From: Sarah Burrow <Sarah.Burrow@arun.gov.uk>
Sent: 25 April 2022 10:28
To: Planning.Responses <Planning.Responses@arun.gov.uk>
Cc: Obafemi Okusipe <Obafemi.Okusipe@arun.gov.uk>
Subject: RE: Planning Consultation on: CM/16/22/DOC

Application No: CM/16/22/DOC

Site Address: Mistletoe Farm Horsemere Green Lane Climping BN17 5QZ

Description of Works: Approval of details reserved by condition imposed under CM/18/21/PL relating to condition 10-surface water drainage.

500MM Ø CONTROFLOW FLOW CONTROL CHAMBER DETAIL
SCALE 1:15

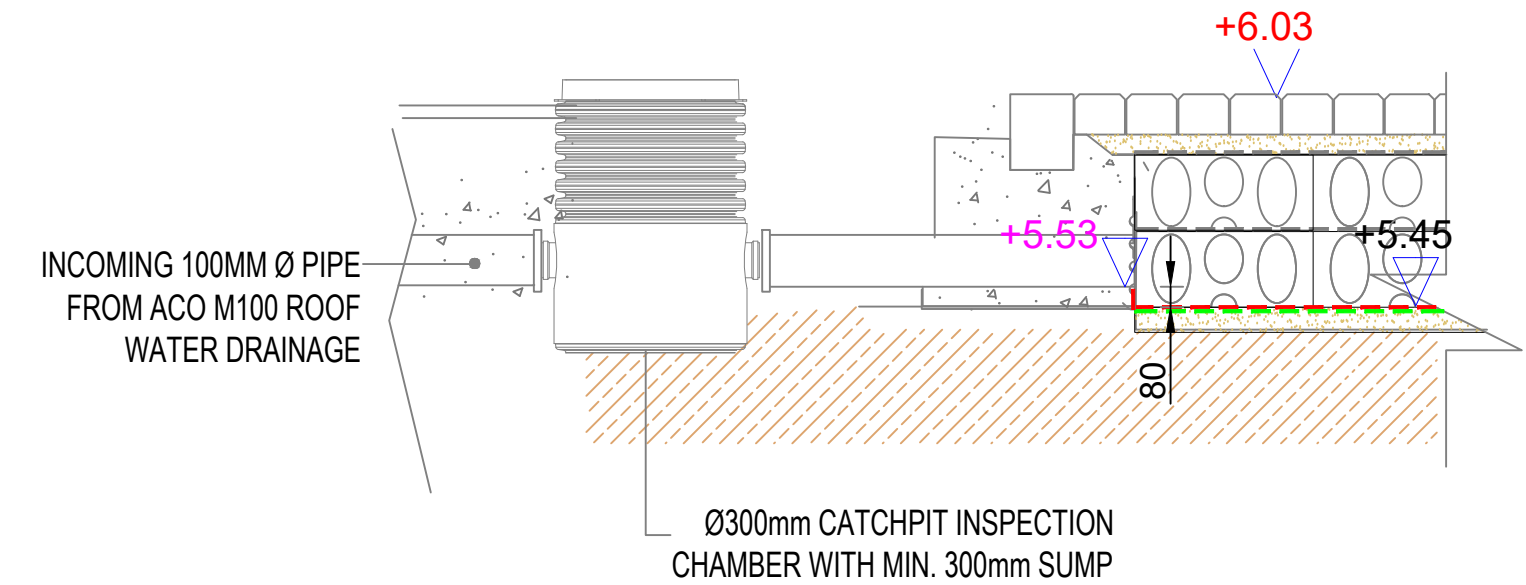
I have followed up on Laura Gibbon's last consultation on CM/72/21/DOC. The only outstanding point that I can see relates to the Controflow flow control with orifice. Please can the applicant provide the previously requested data, assuming that this can be provided and is appropriate for this design then I will be happy to discharge the condition.

Former point 11: Please provide Controflow data to evidence orifice size and level are suitable.
